TfNSW Reference: SYD20/00506/05

DPIE Reference: SSD-10457

**ADDITIONAL INFORMATION AND UPDATED SIDRA FILES EASTERN CREEK
RETAIL OUTLET CENTRE - LOT 3 ROOTY HILLS ROAD, EASTERN CREEK**

Title
**INTERSECTION LAYOUT-CONCEPT
LINEMARKING PLAN,**

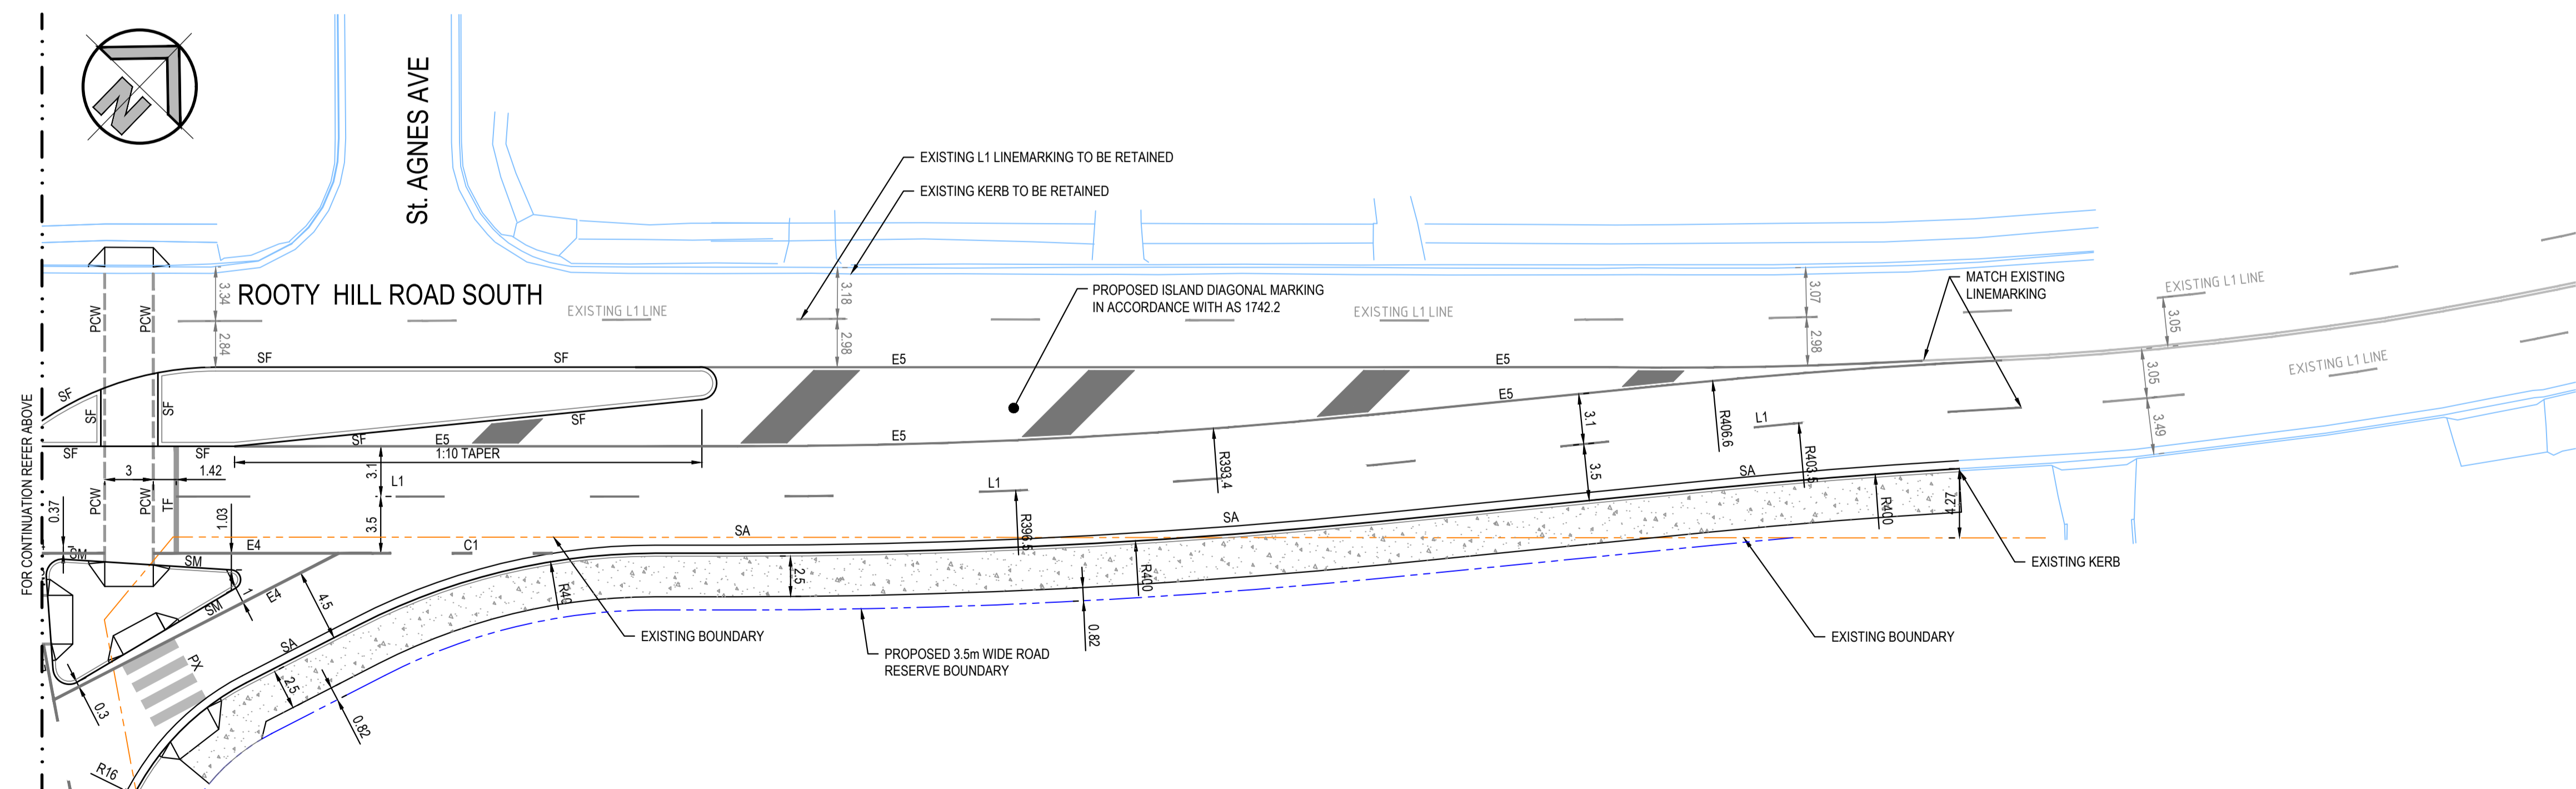
1. The proposed length of the northbound right turn bay in the draft design is inconsistent with the SIDRA model. The proposed right turn bay should be amended to adequately accommodate right turning vehicle queuing without impacts on the operation of through traffic lane. The traffic model should be updated with the correct inputs to correct this.

2. It is noted that if the right turn bay is extended then the design will impact on the intersection of Beggs Road.
3. The applicant and Council will need to consider the left-in/left-out impacts on St Agnes Avenue, Minchinbury Street and potentially Penfold Street. Adequate community consultation will need to be undertaken with Council and the affected communities. Evidence will need to be provided that this community consultation has been undertaken.

4. The proposed central median across Minchinbury Street along Rooty Hill Road South is not long enough to self-enforce the proposed left-in/left-out arrangement at Minchinbury Street.

5. The draft design indicates that the pedestrian refuge is not in line with the proposed pram ramps at the Beggs Road intersection. The draft design also does not indicate if the median is wide enough to cater for a 6 aspect lantern arrangement.

6. The width of 2.8m for the proposed northbound right turn lane is not acceptable to TfNSW. The design of the right turn lane should be in accordance with AUSTRROADS GUIDE TO ROAD DESIGN and other Australian Codes of Practice.

7. All lane widths in the design need to be identified (for new and existing).
8. The design speed must be 70km/hr to cater for a posted speed limit of 60km/hr.

INTERSECTION LAYOUT - TURNING PATHS

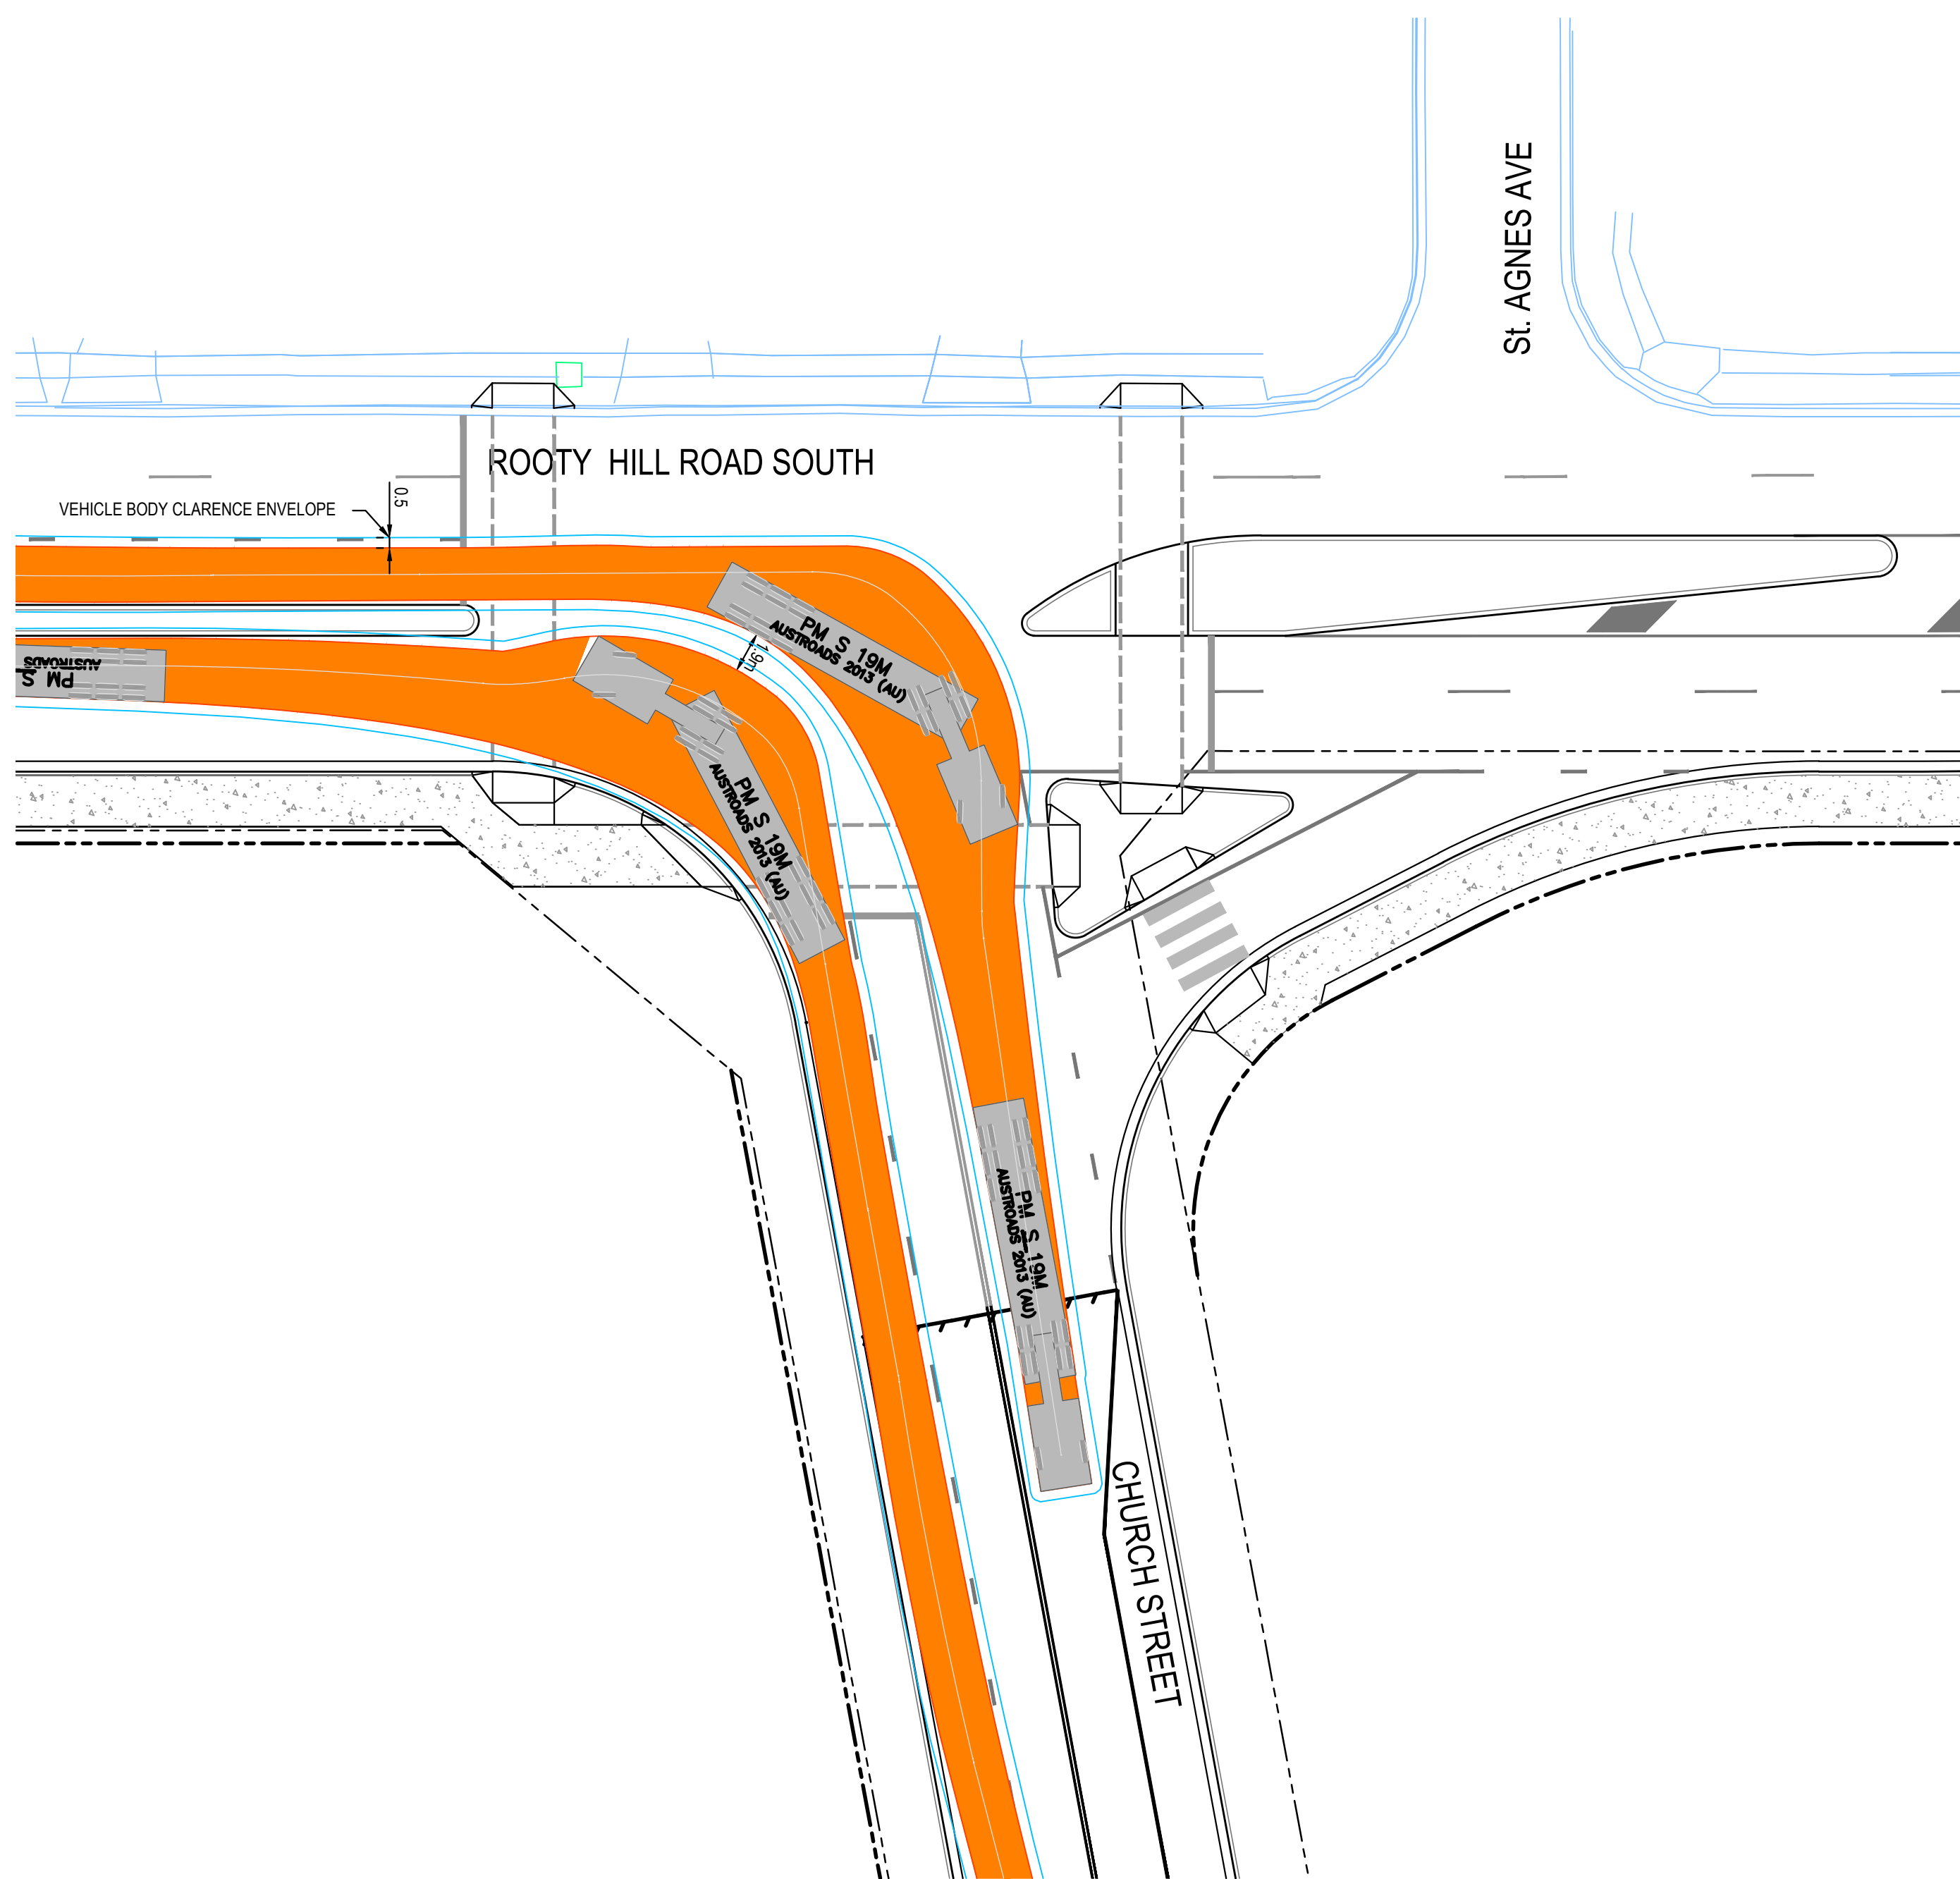
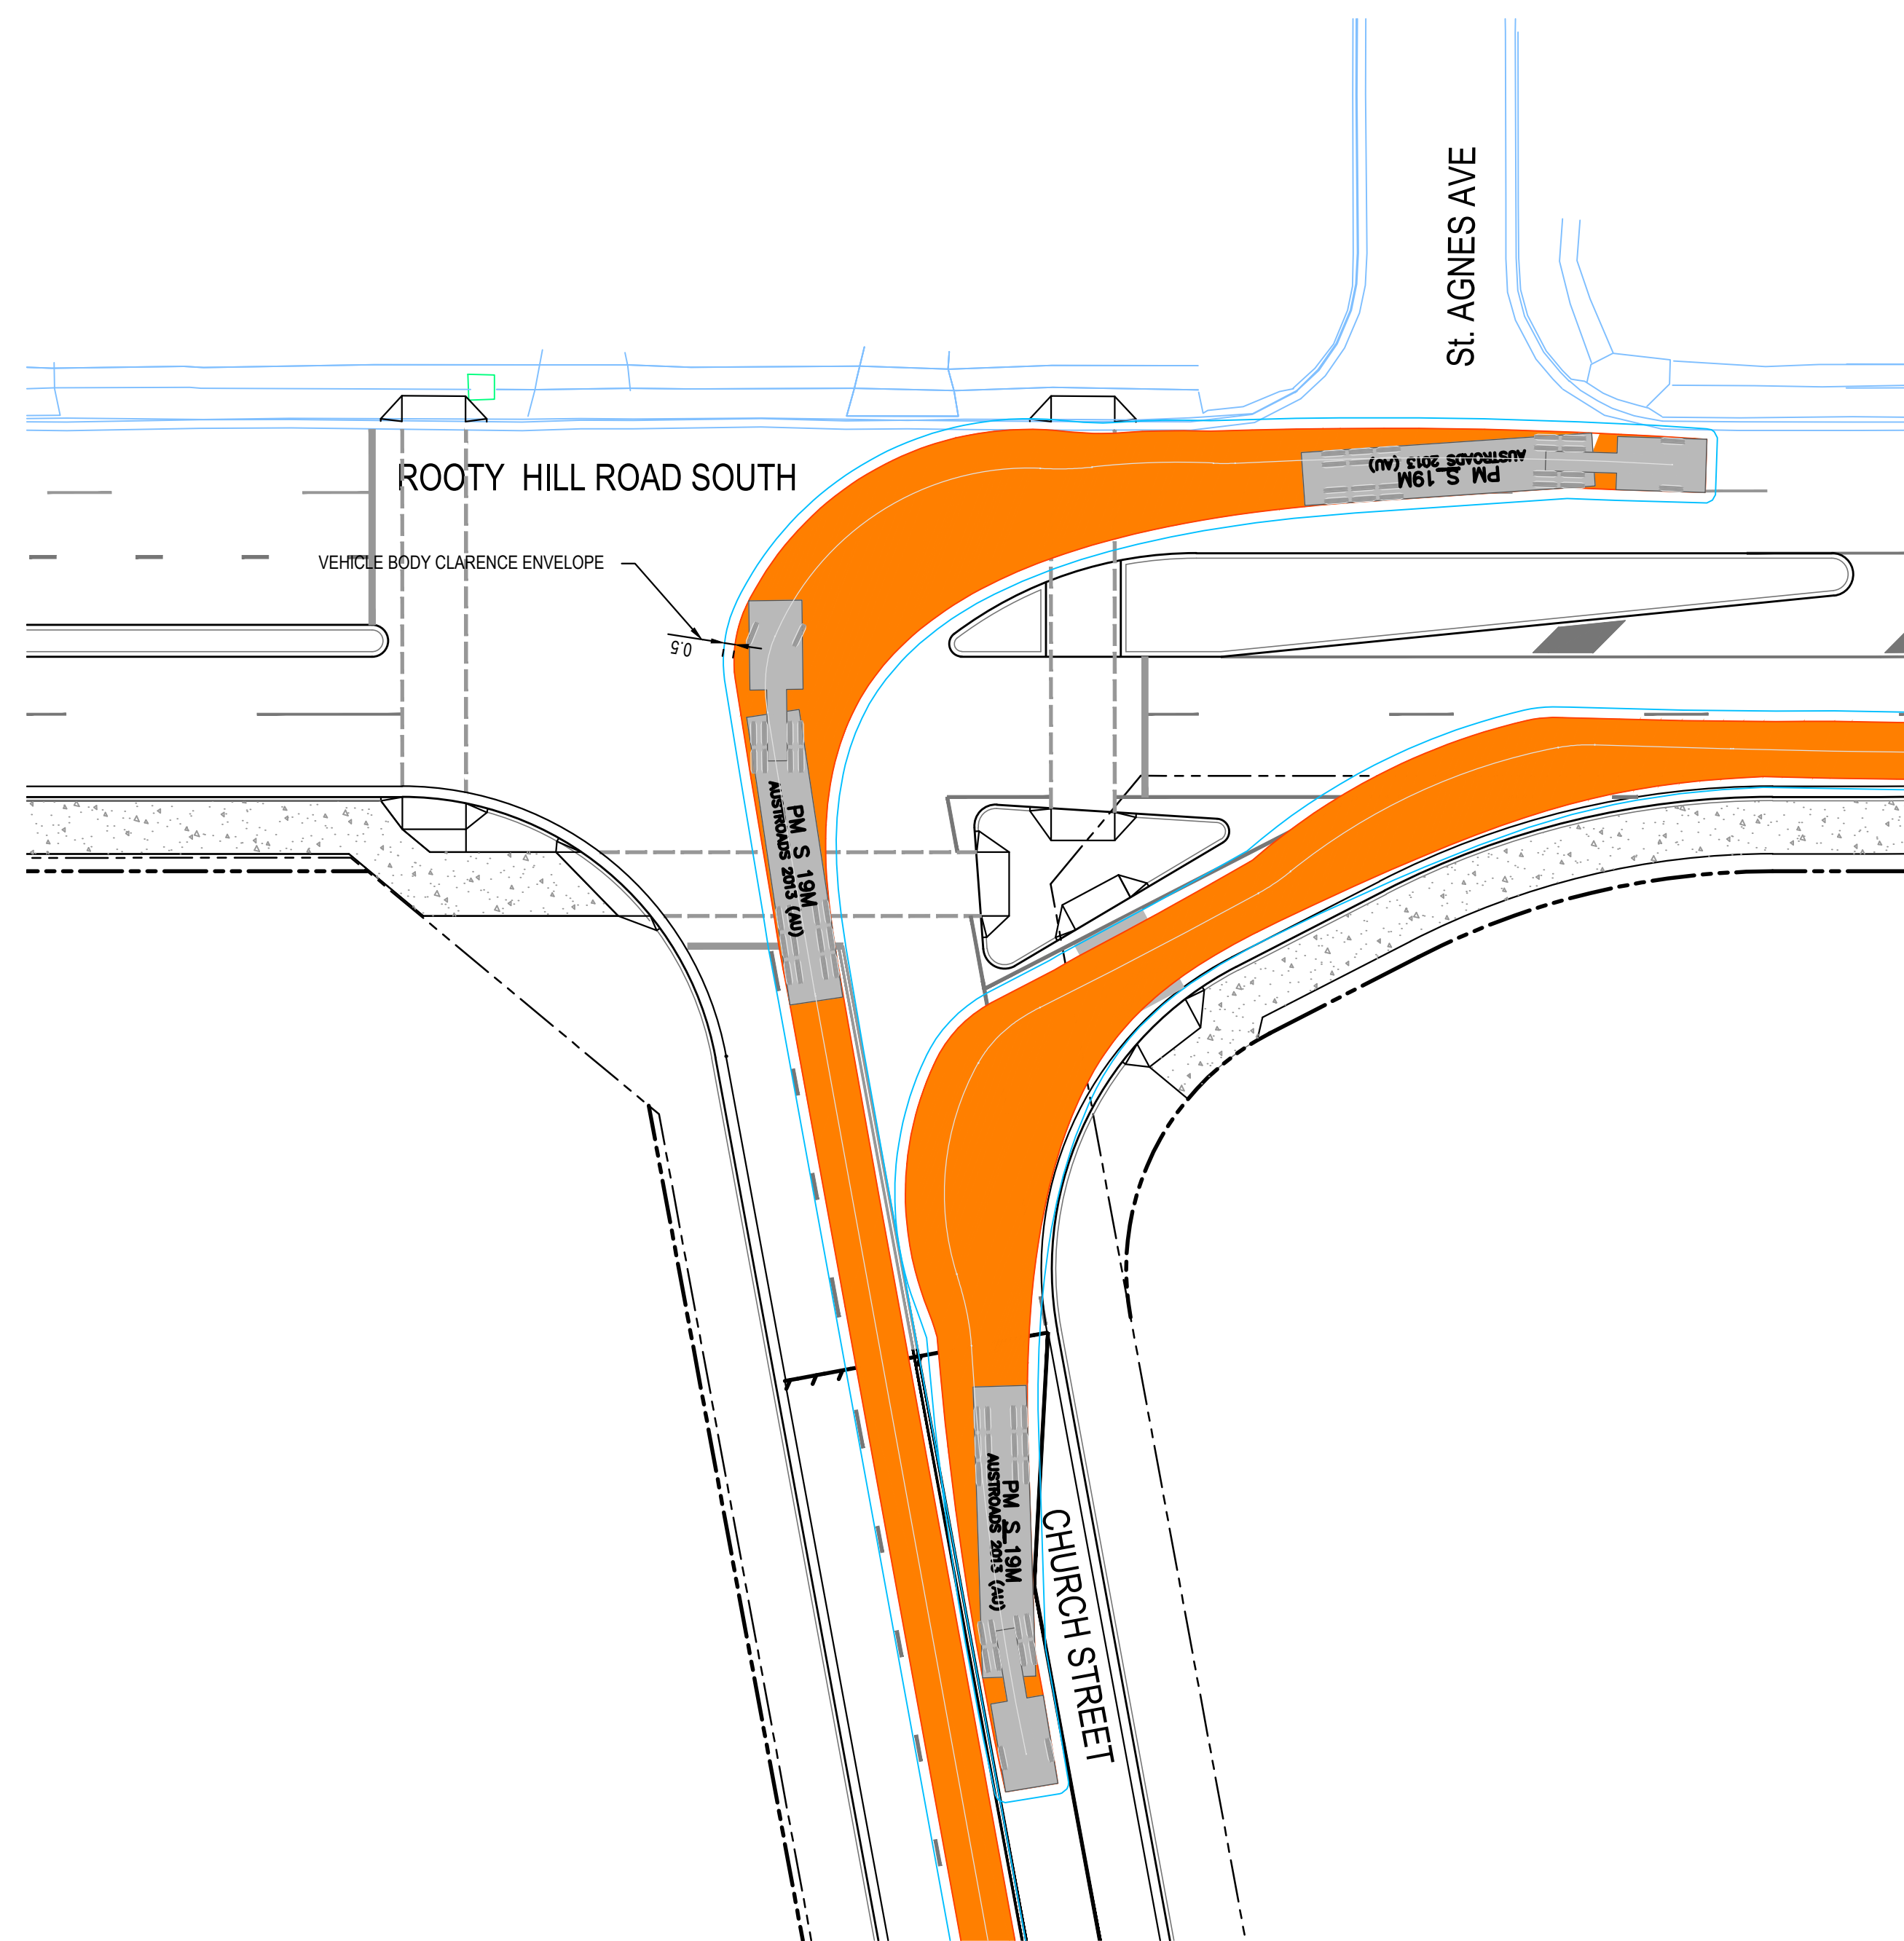
10. Concept civil design plans, swept paths and a draft Traffic Control Signal (TCS) plan of the proposed Rooty Hill Road South /Church Street intersection need to be submitted to TfNSW for review and approval.
